FALL MOUNTAIN FARM DEVELOPMENT PHOTOMETRIC SITE PLAN

ELECTRICAL PHOTOMETRIC SITE PLAN

Lighting Plan_V1.pdf Markup Summary

ELECTRICAL PHOTOMETRIC SITE PLAN

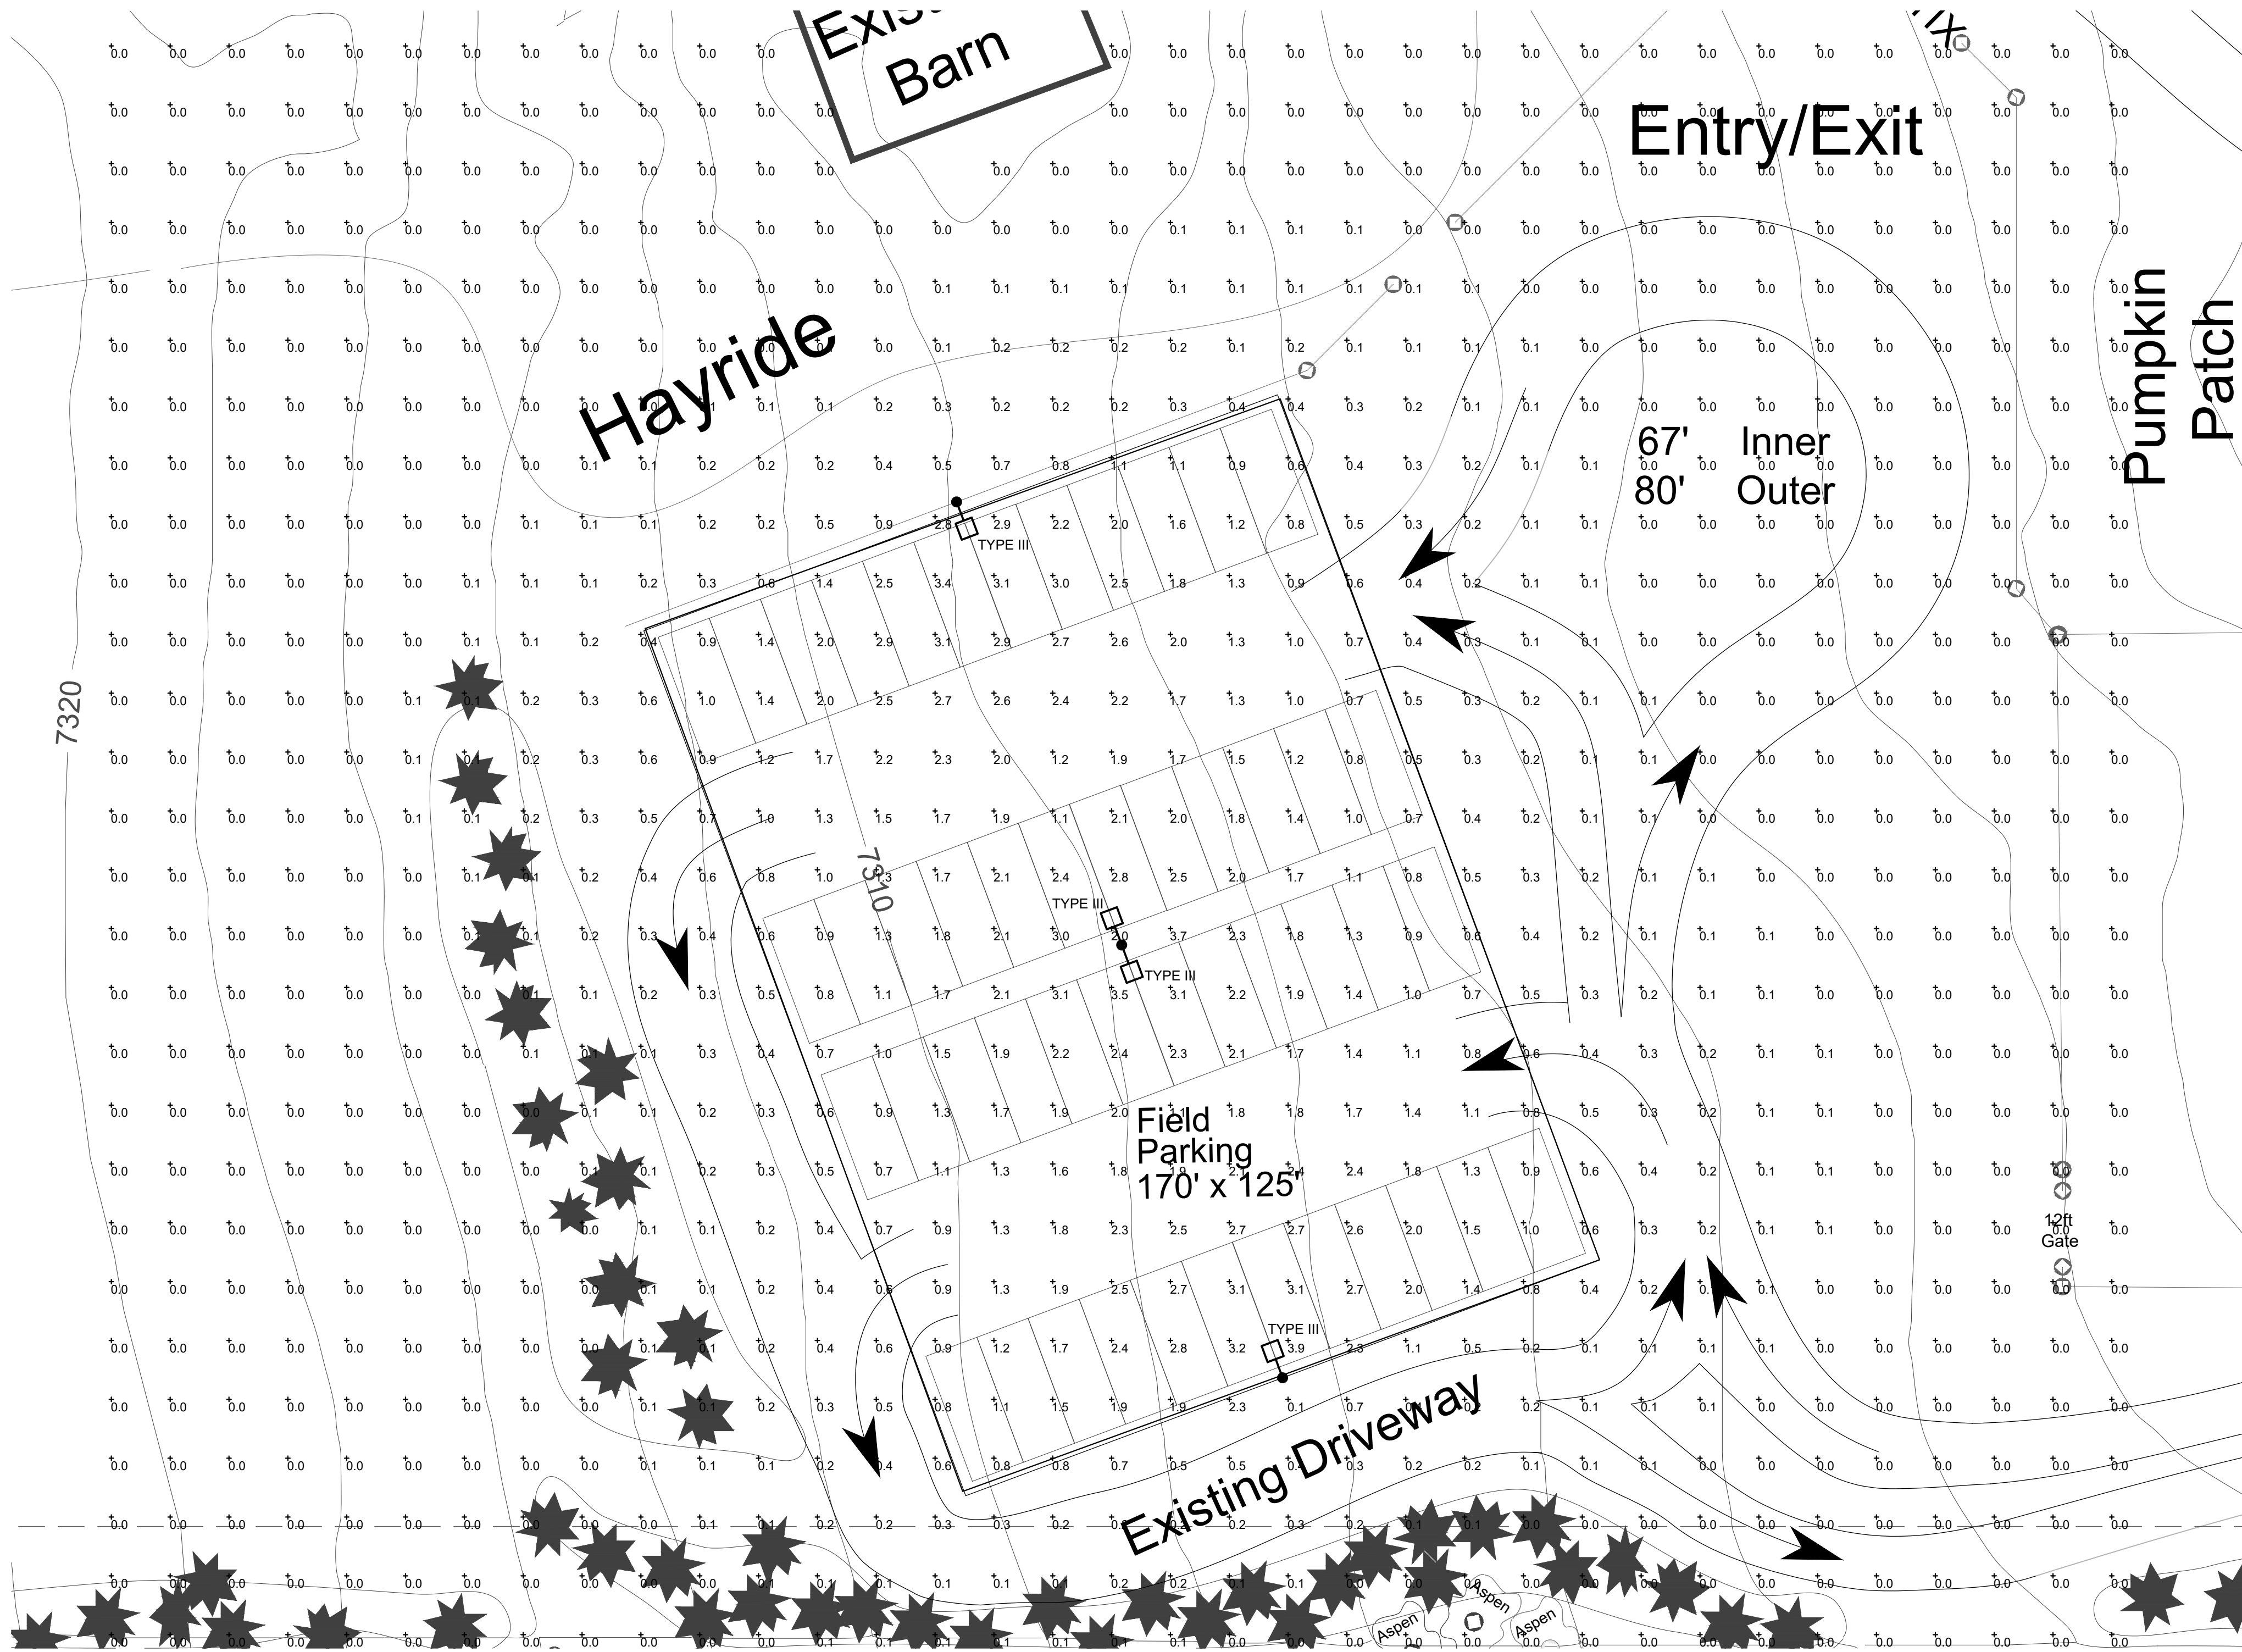
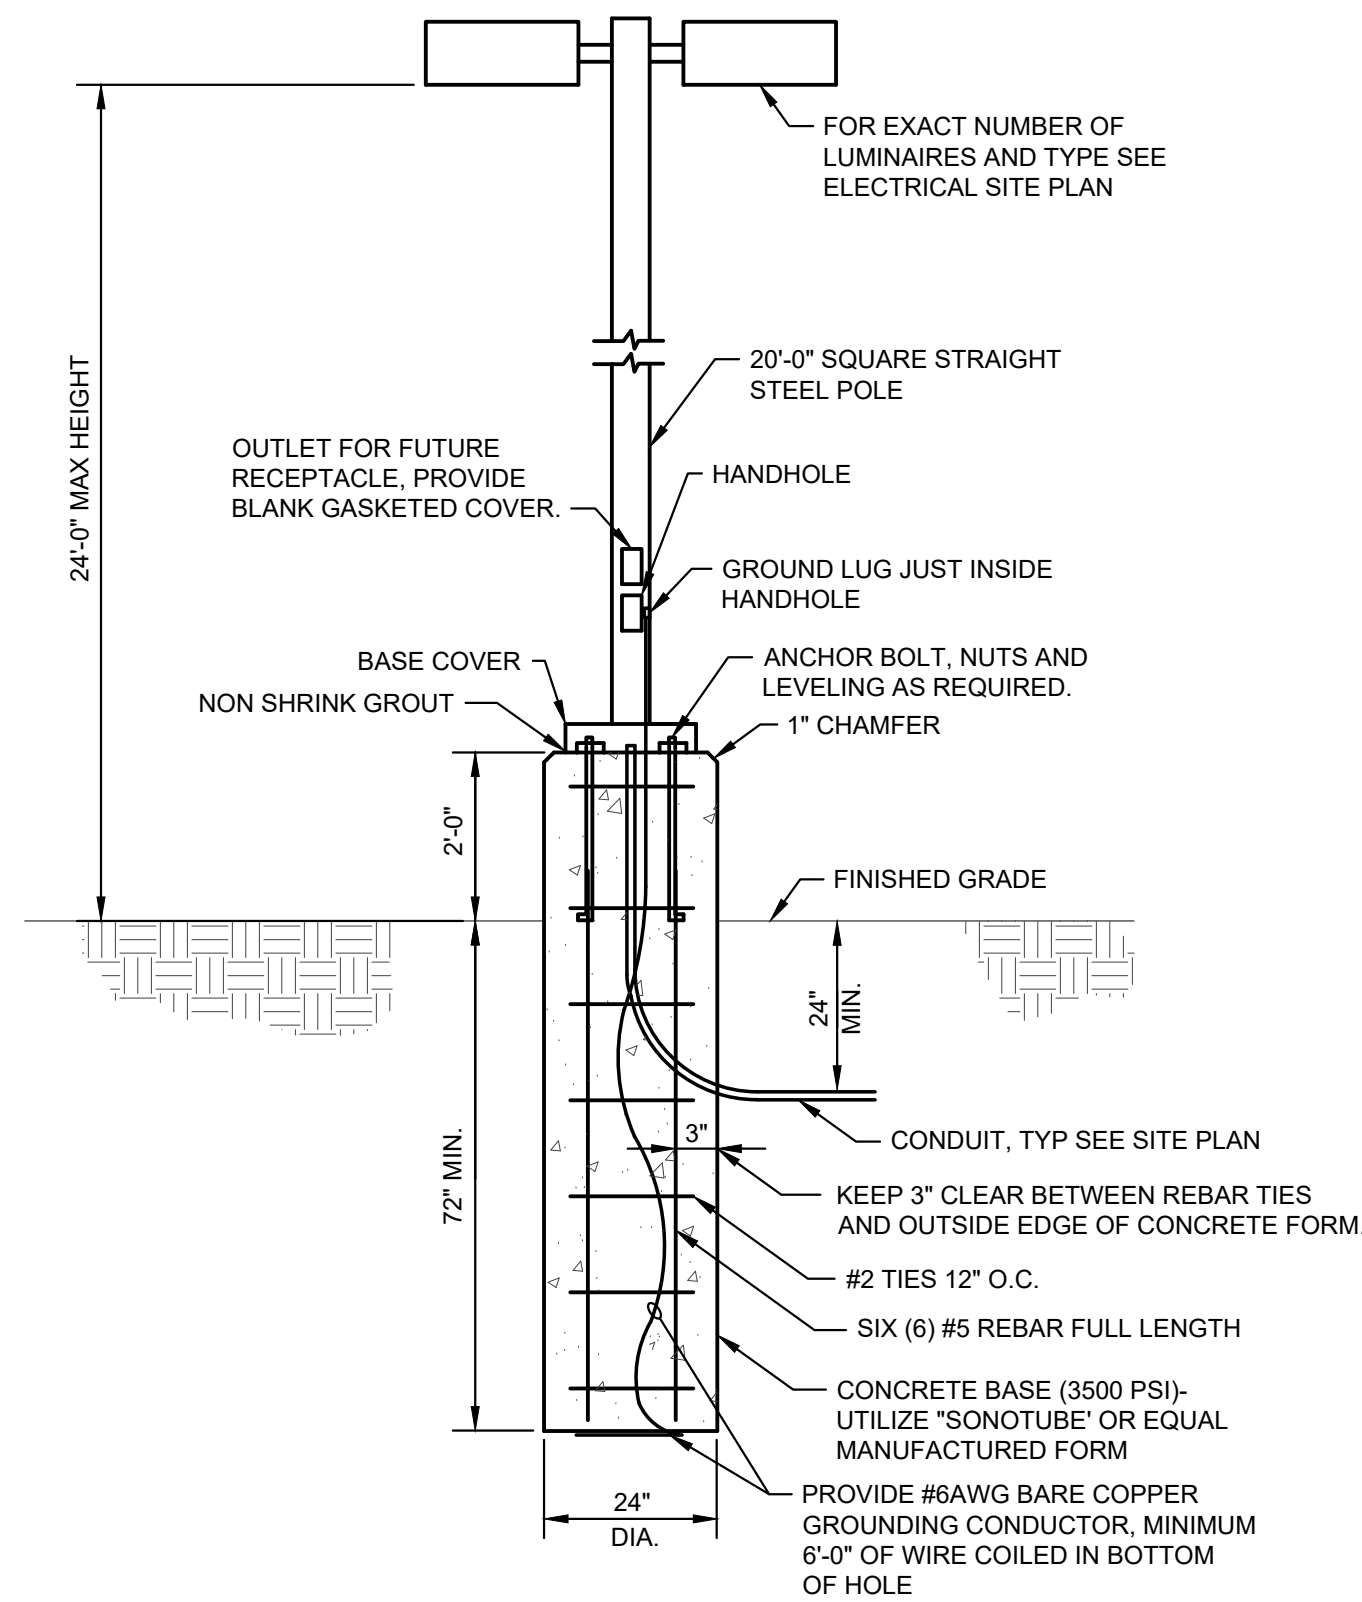
6.2.3.(B)(2)Height. No freestanding light fixtures shall be mounted higher than 15 feet, except parking lot light fixtures which shall be mounted no higher than 20 feet unless an alternative lighting proposal is approved in accordance with this Code.

- Please add to the plan:
- Owner/Applicant name and contact phone # & email.
- Plan preparer name & contact phone #
- Show the location and height of all existing and proposed illuminating devices, including but not limited to, all parking area lights and external structural lights for all three parcels.
- Photometric plan depicting the lighting levels (foot candles) throughout the property, at property lines, and along any adjacent rights-of-way.
- Show location of all existing and proposed easements
